Norwich to Tilbury Project (the “Project”)

Application Ref: EN020027

ScottishPower Renewables (UK) Limited and East Anglia THREE Limited’s Deadline 5 Submission

THE NATIONAL GRID (NORWICH TO TILBURY) ORDER  
 LAND PLANS  
 REGULATION 5(2)(i)-(iii)  
 SECTION B (SHEET 20 OF 22,  
 MID SUFFOLK DISTRICT COUNCIL AND BABERGH DISTRICT COUNCIL)

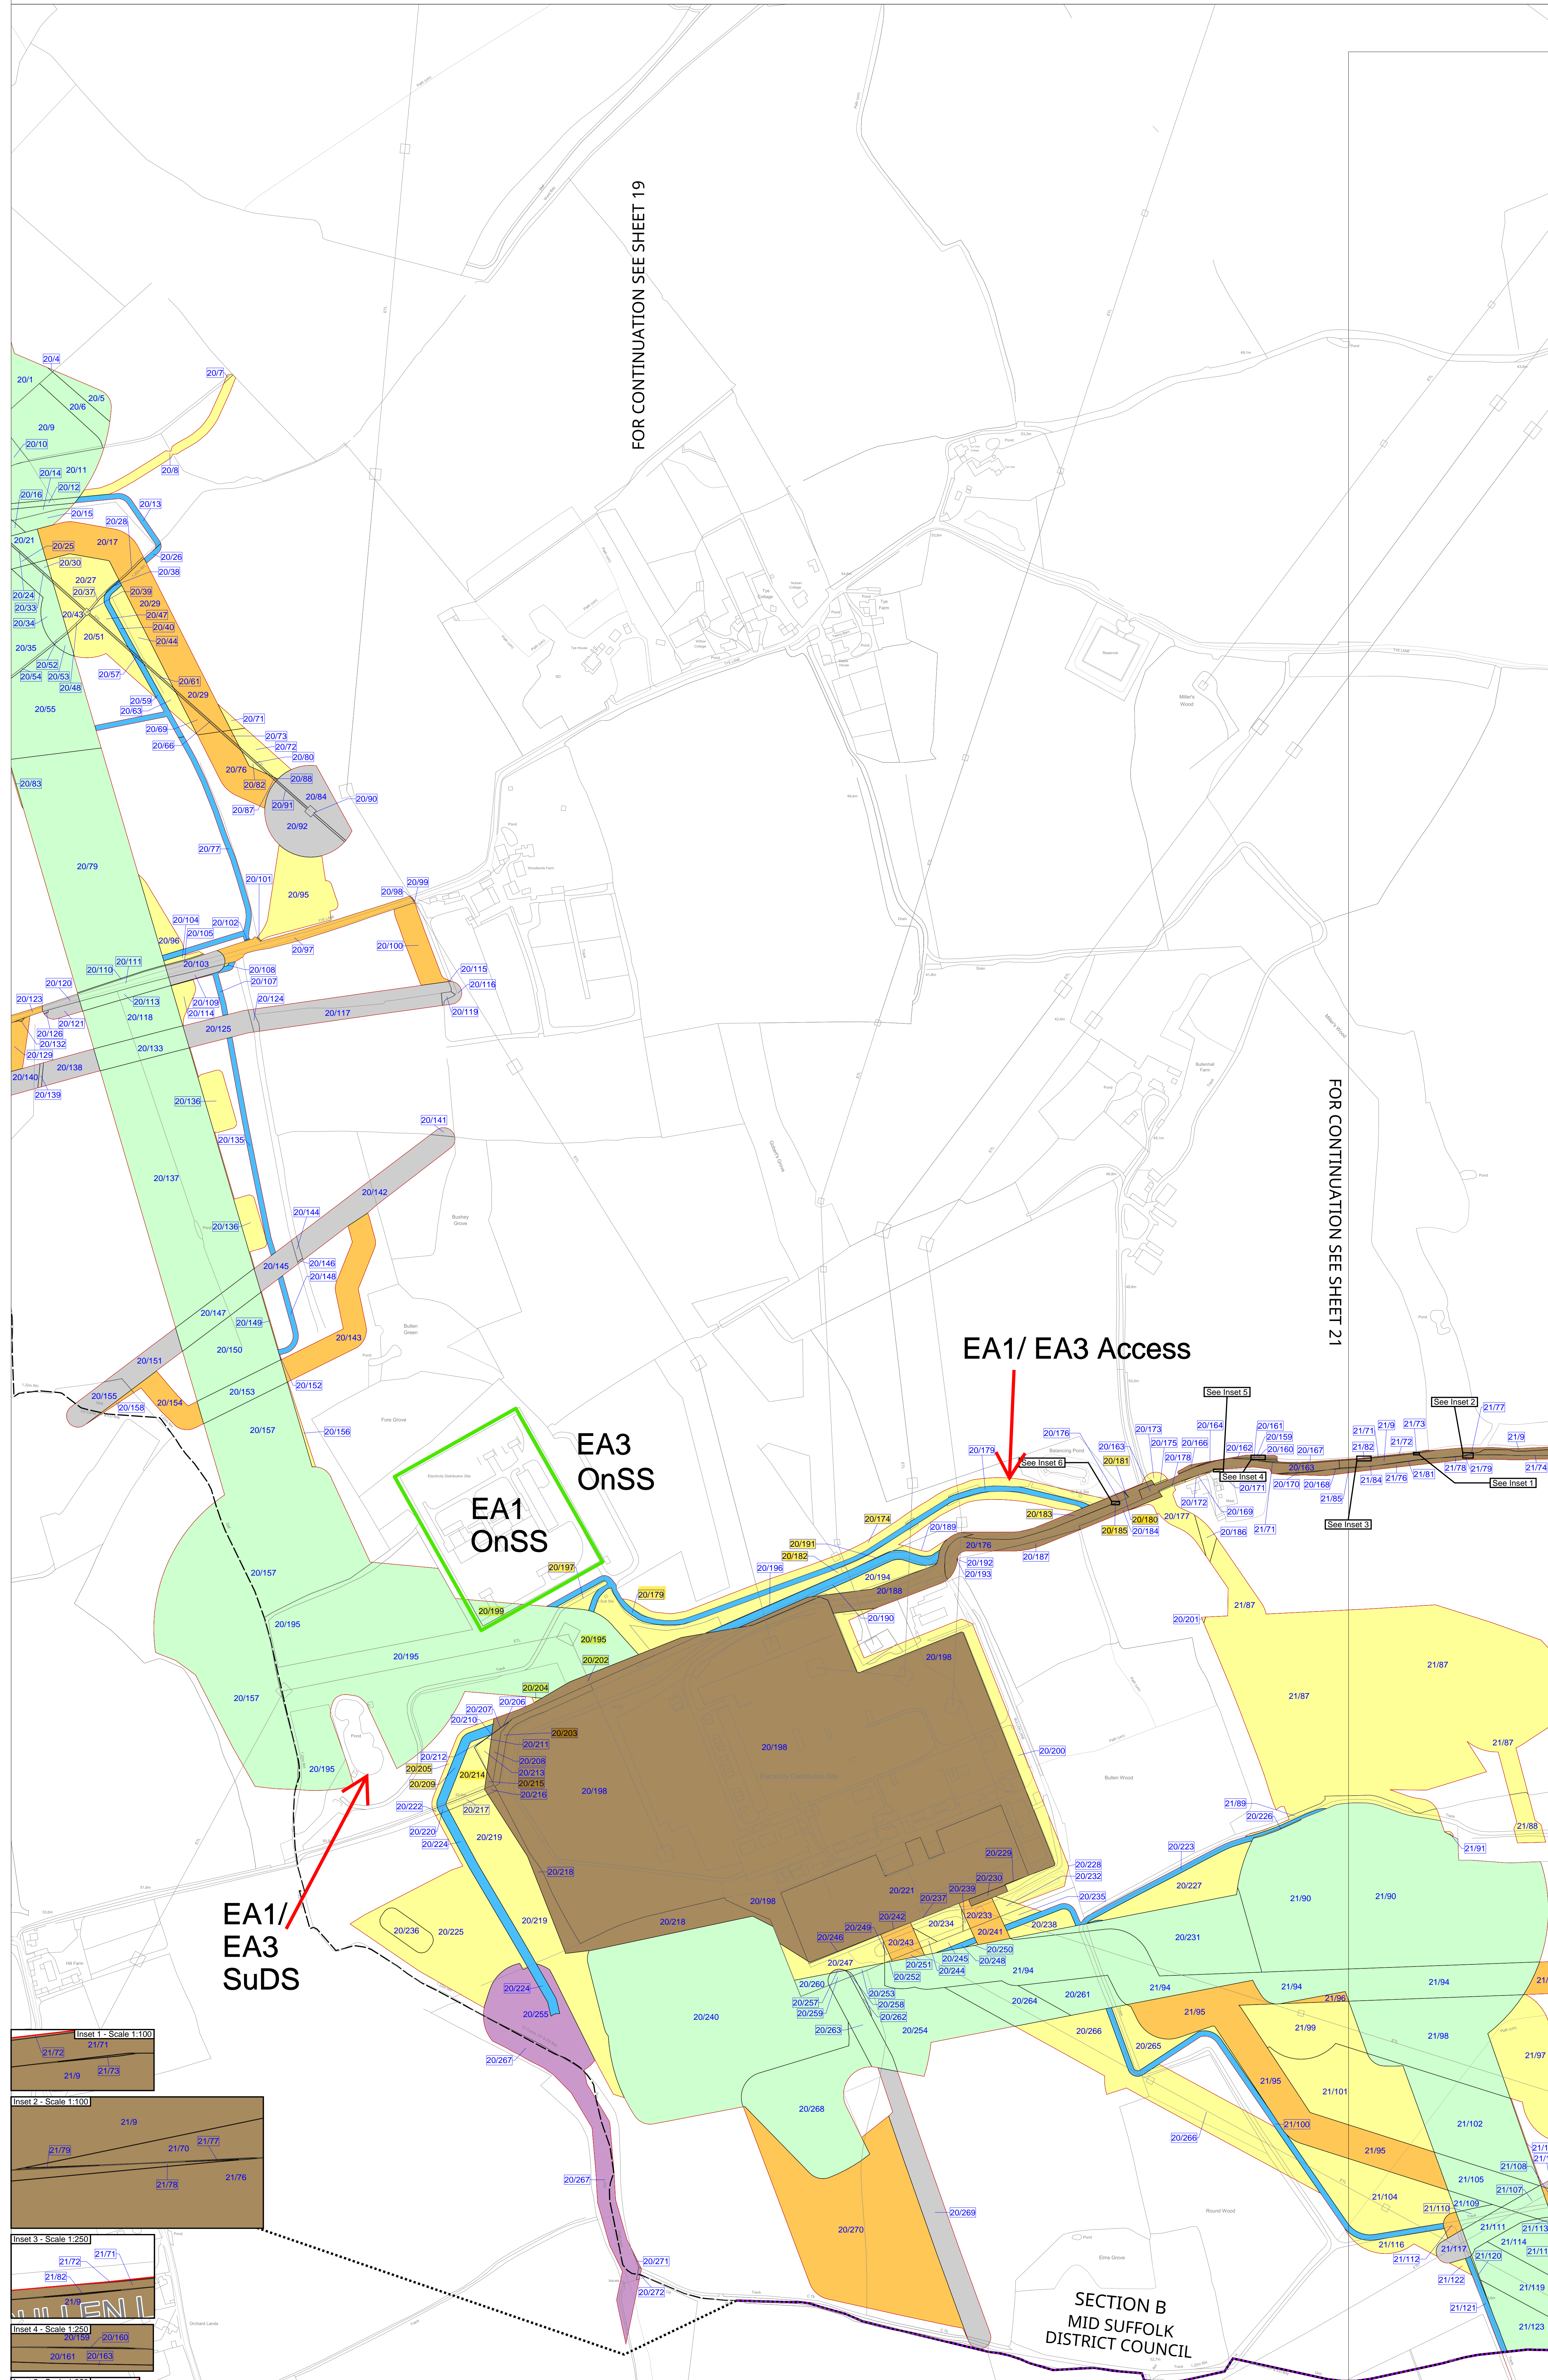
- 2.3 **Land Plans – Section B [REP4-008]**
- 2.3.1 At present, plot B-20/180 is coloured brown on the Land Plans which would indicate that it is Class 1 land (compulsory acquisition of land). However, the Book of Reference [REP4-049] and the Statutory Undertaker Tracker [REP4-305] both note it as Class 7 land (temporary use). We therefore ask that the Applicant confirms the classification of plot B-20/180 and that the relevant documents and/or plans are updated accordingly at Deadline 6.
